DEYOUNG SUBDIVISION

SHEET 1 OF 1

Engineering Review
06/17/2020 12:03:33 PM
dsdrice
JeffRice@elpasoco.com
(719) 520-7877
EPC Planning & Community
Development Department

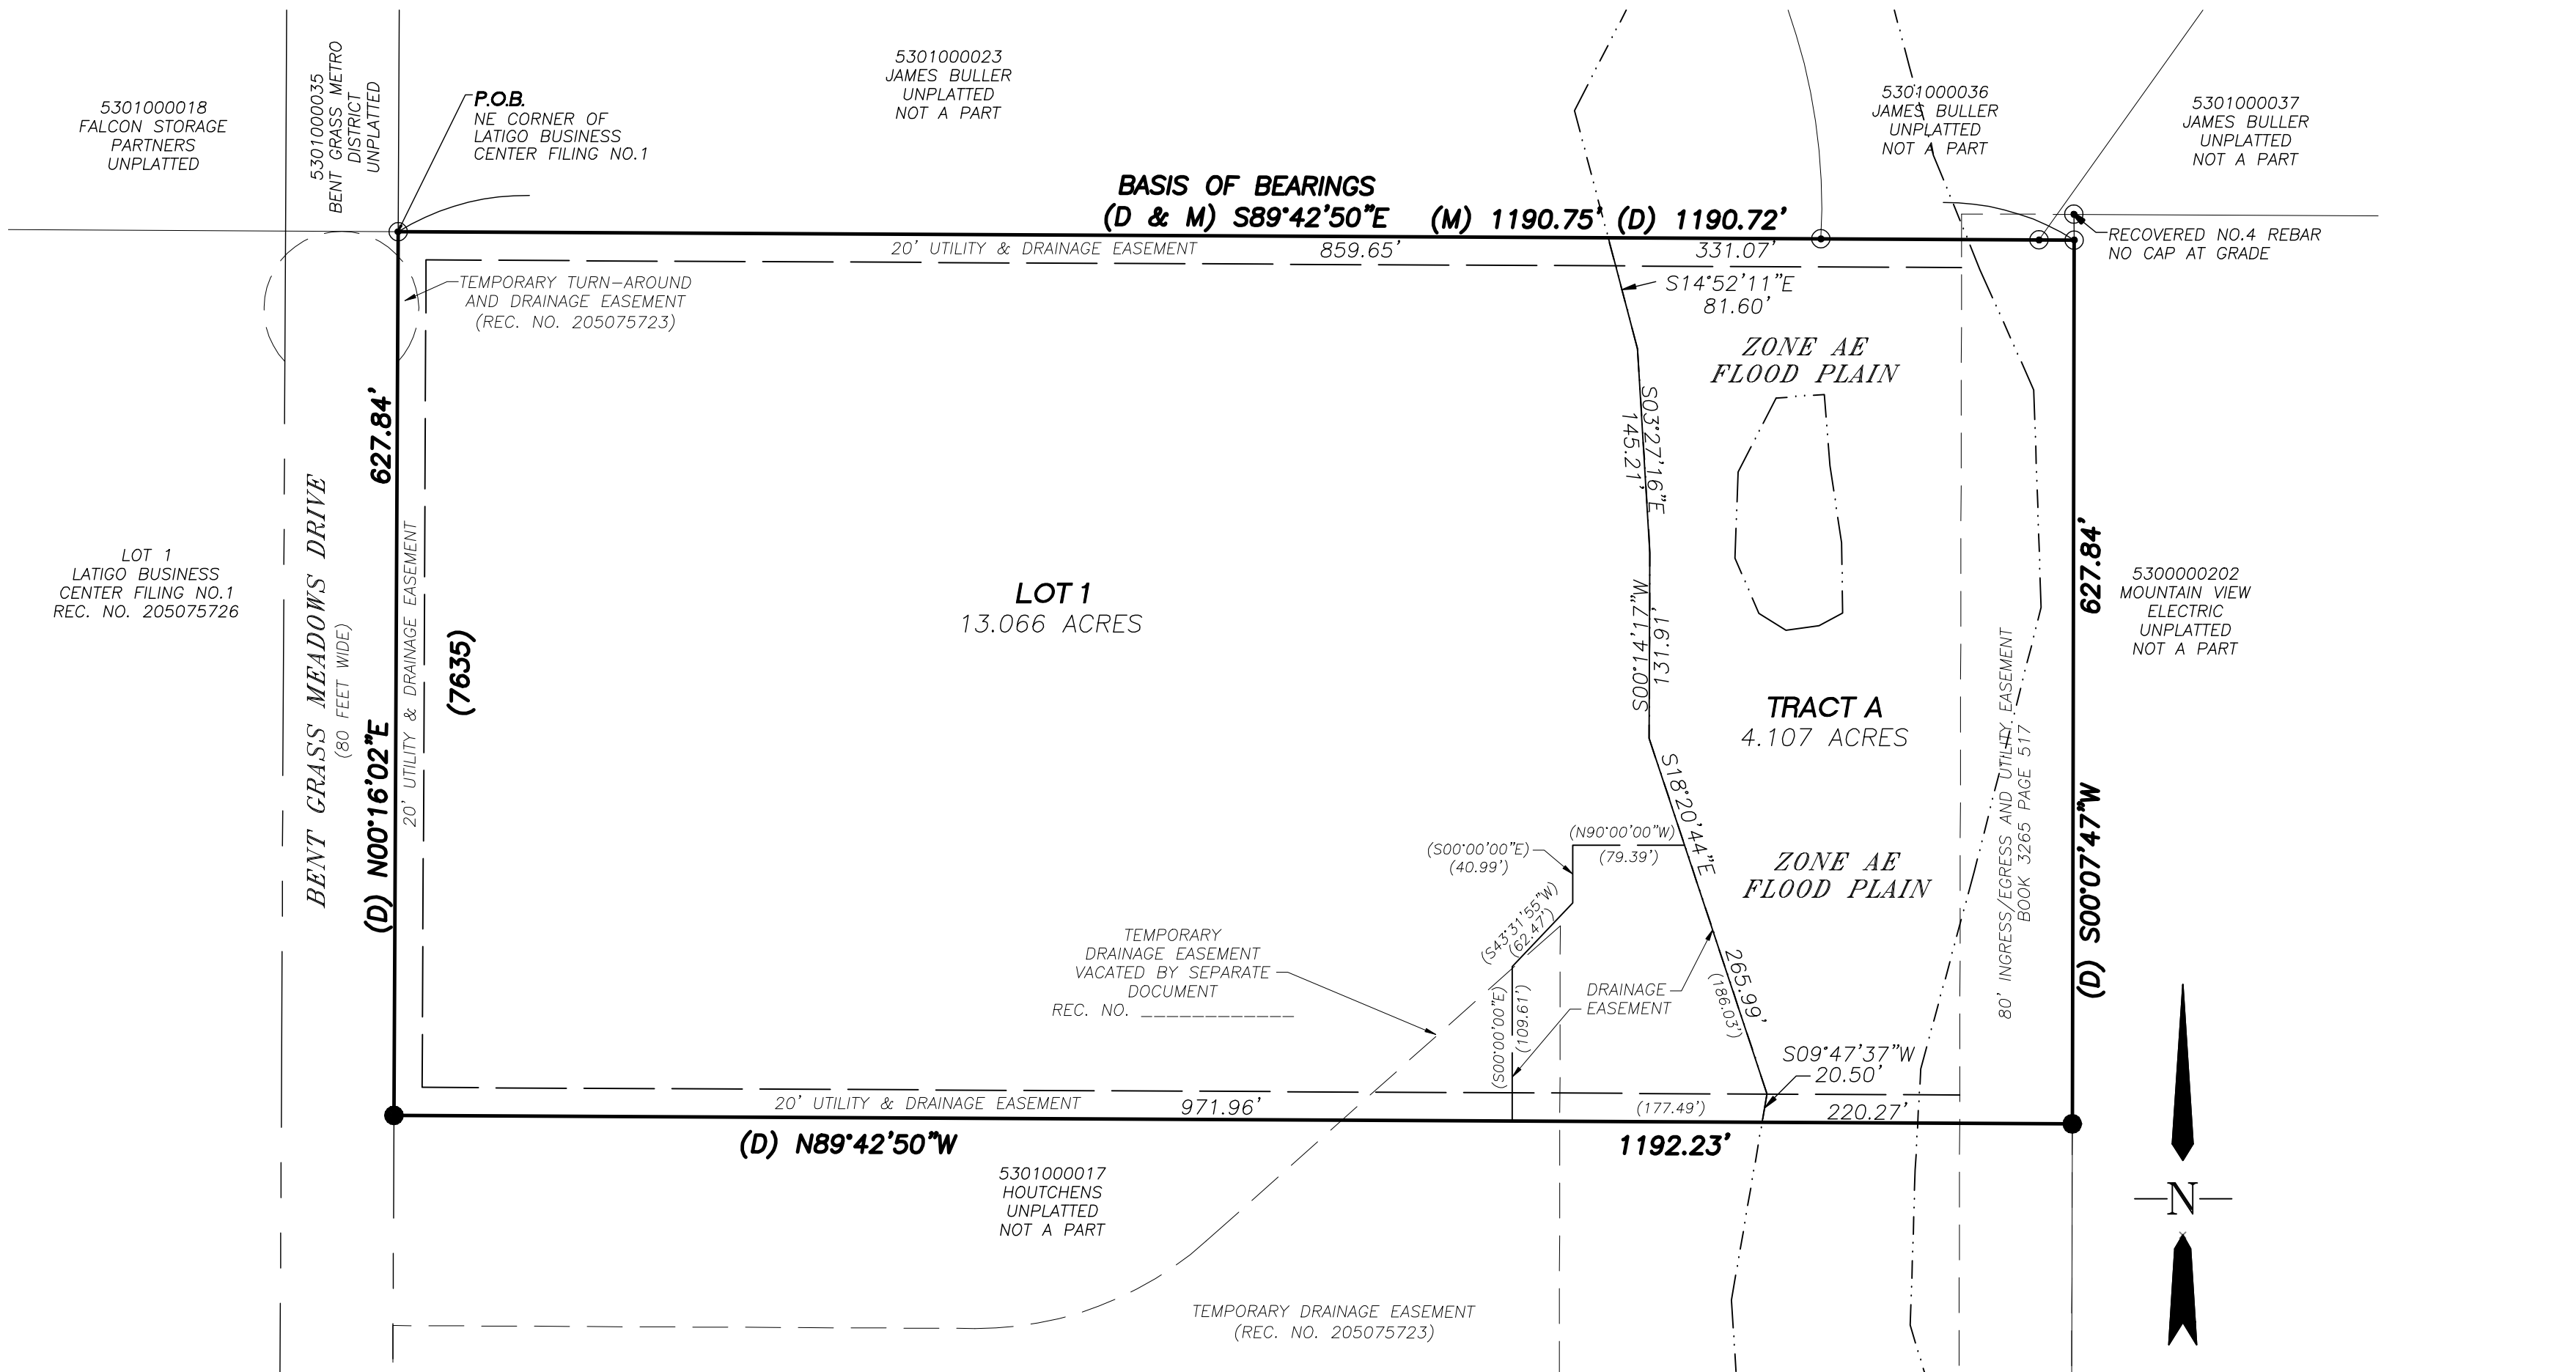
See comment letter also.

NOTES: or material storage. See RBD Floodplain comments.

Soils and Geology report has been updated. Revise to reflect new report and explain what the specific geologic hazards are.

This note is not needed if the property is in the Woodmen Road Metro District

include this number

Previous comment not addressed: provide note regarding Floodplain: No structures or fences are permitted within designated 'Floodplain' or 'Park and Open Space' areas. (Modification of this note may be allowed if the plan approved by the Floodplain Administrator, provided this creates no conflict with approved plans or conditions.) This property is located within a designated FEMA Floodplain as determined by the Flood Insurance Rate Map. Community Map Number _____, effective date _____ (modification when LOMR has been approved) and as amended by the FEMA approved Letter of Map Revision (LOMR) case number dated _____. No structures are permitted within the designated Floodplain areas. (Modification of this note may be allowed if the intent is to allow construction of structures through the Floodplain Development Permit Process- example: retaining wall in excess of 4 feet is a structure)
